Subject: 2025/91965 at location land at, Gelderd Road, Birstall, Batley, WF17 9LS

Please see ecological commentary below:

Proposed Site Plan
Lighting

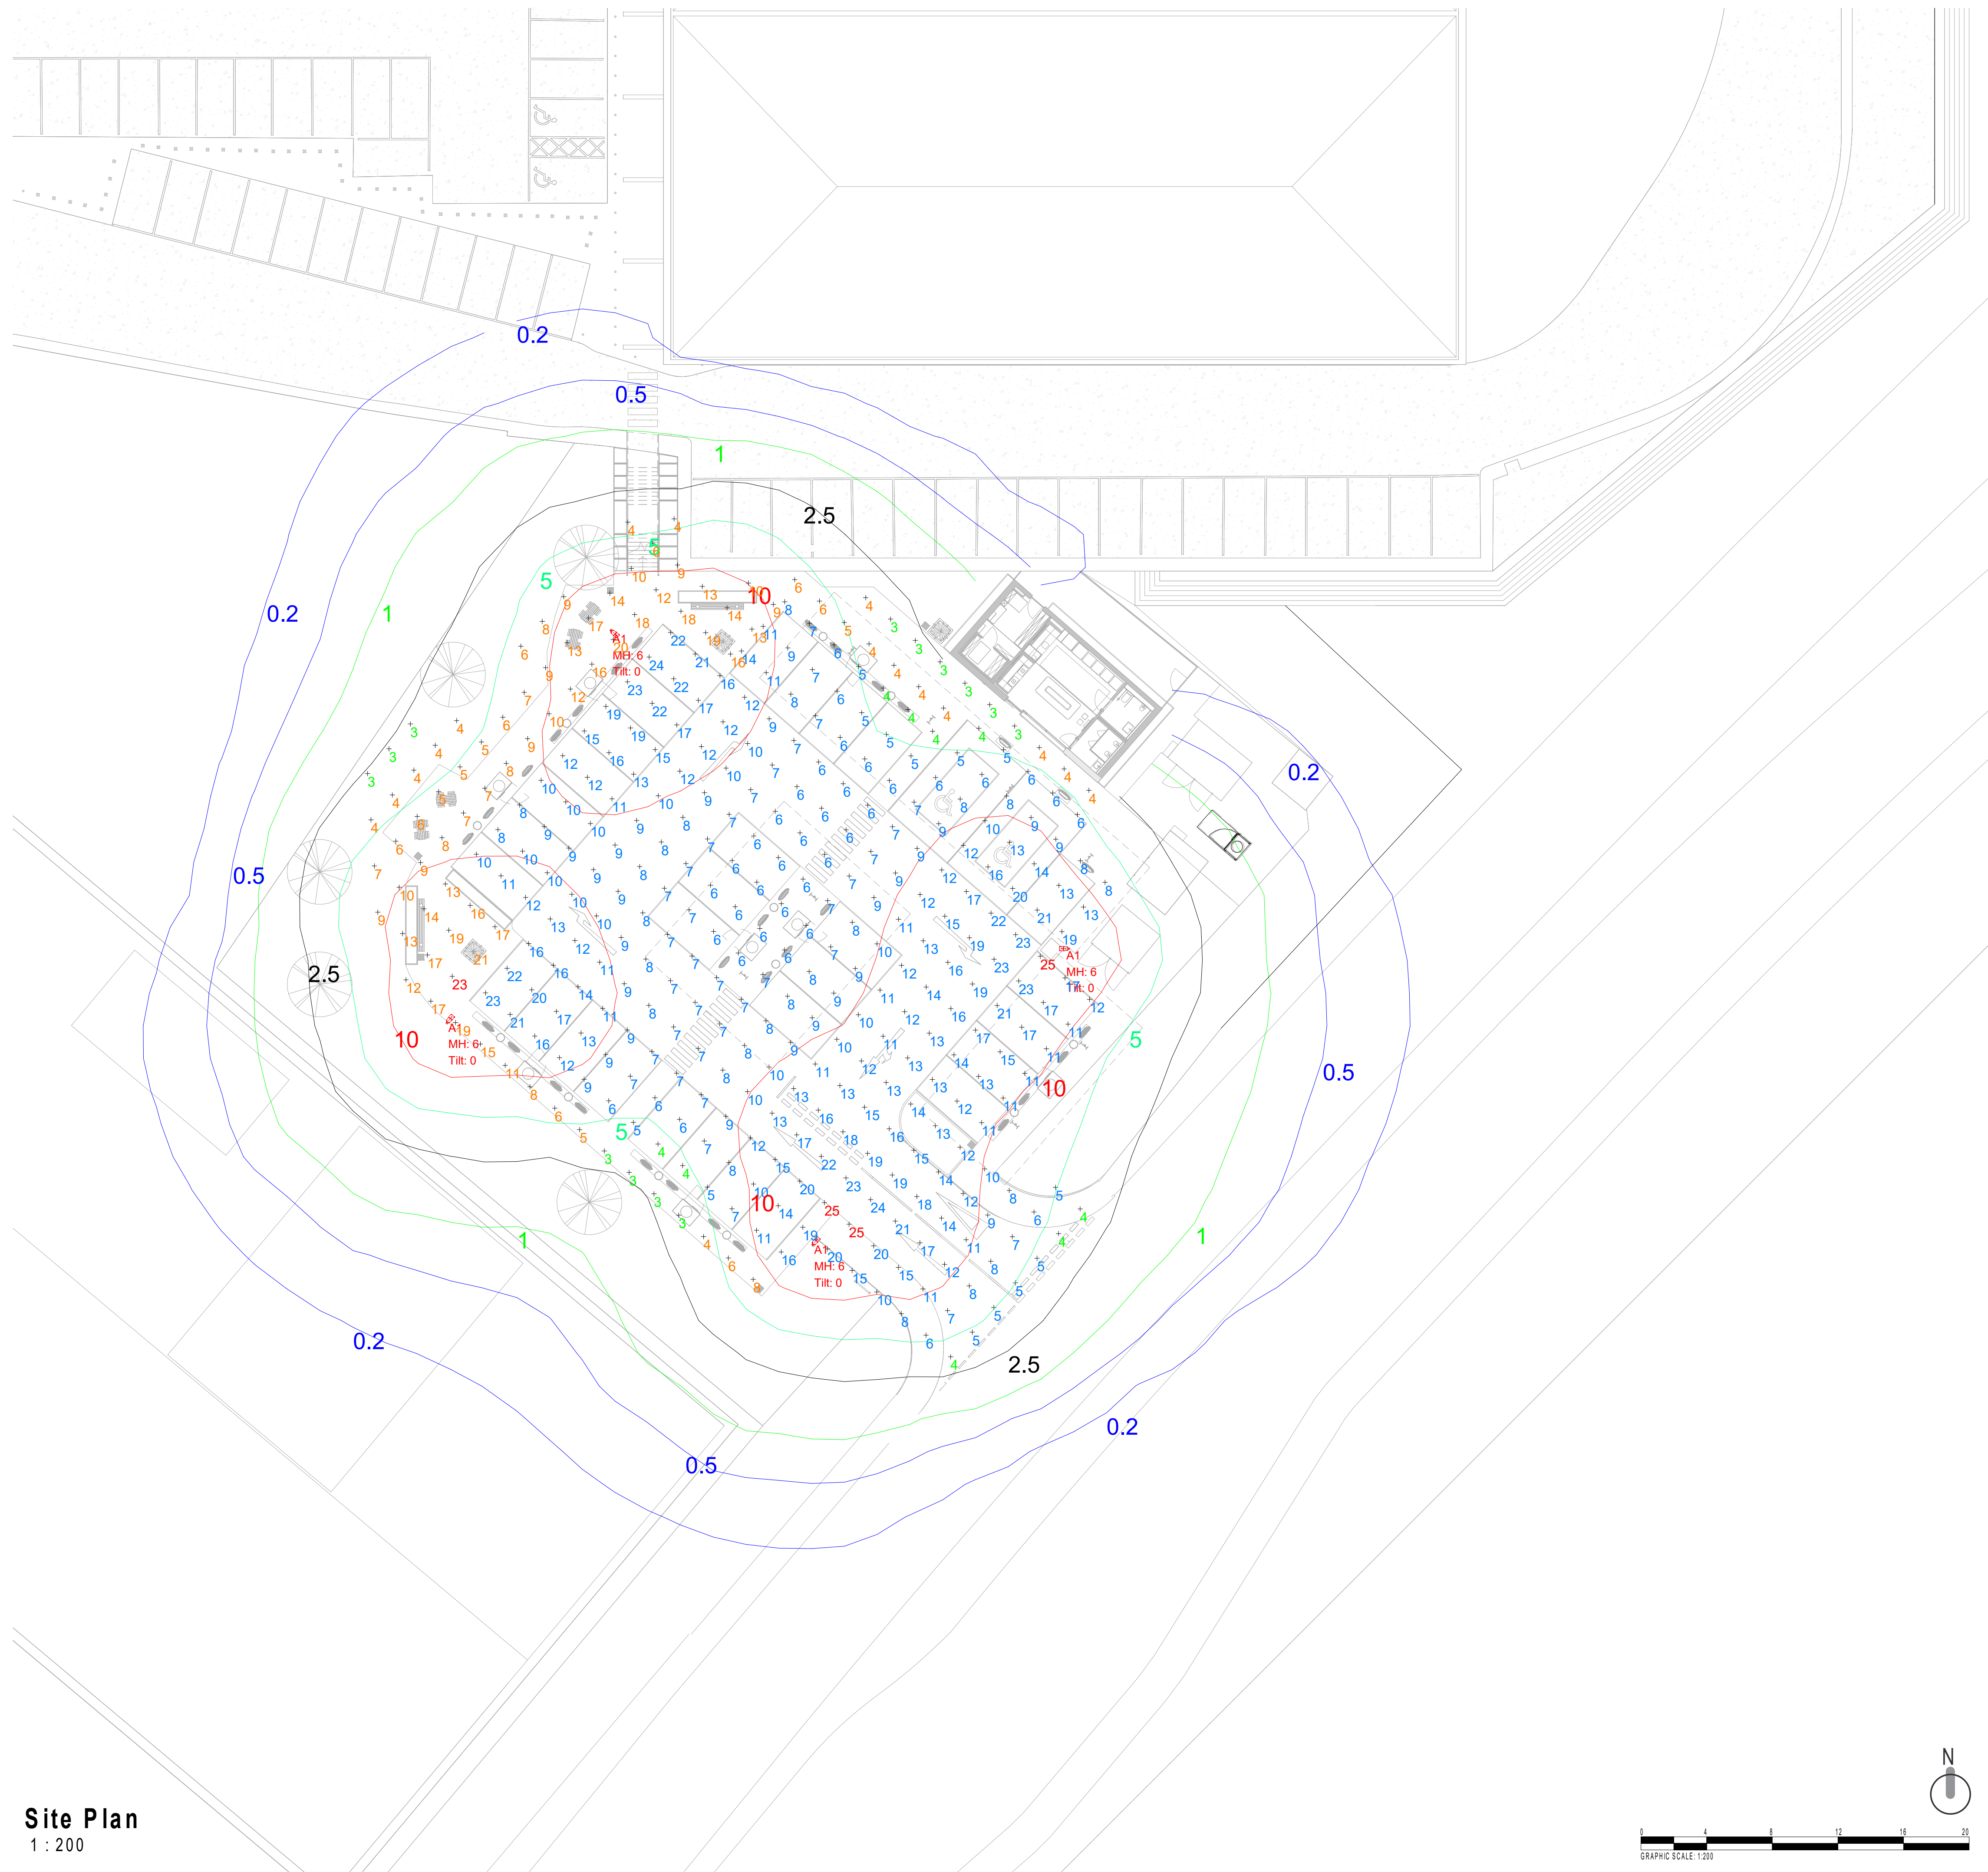
- Bats – The PEA mentions that the building onsite was considered to have moderate potential for roosting bats. Bat emergence surveys were conducted in 2023, and it was observed that roosting bats were likely absent. Precautionary working methods are recommended. As surveys has not been updated a PWMS will be conditioned. Lighting conditions will also be added.

No works are to commence unless a detailed lighting scheme, developed in accordance with established guidance (e.g. Bat Conservation Trust and Institute of Lighting Professionals (2023) Bats and Artificial Lighting at Night), has been drafted and agreed with the council. The Sensitive Lighting Strategy will demonstrate that the proposed lighting will not impact upon ecological networks and/or sensitive features. Thereafter the agreed lighting scheme shall be implemented, subject to any variations approved in writing by the planning authority. All external lighting shall be installed strictly in accordance with the specifications and locations set out within the Lighting Strategy.
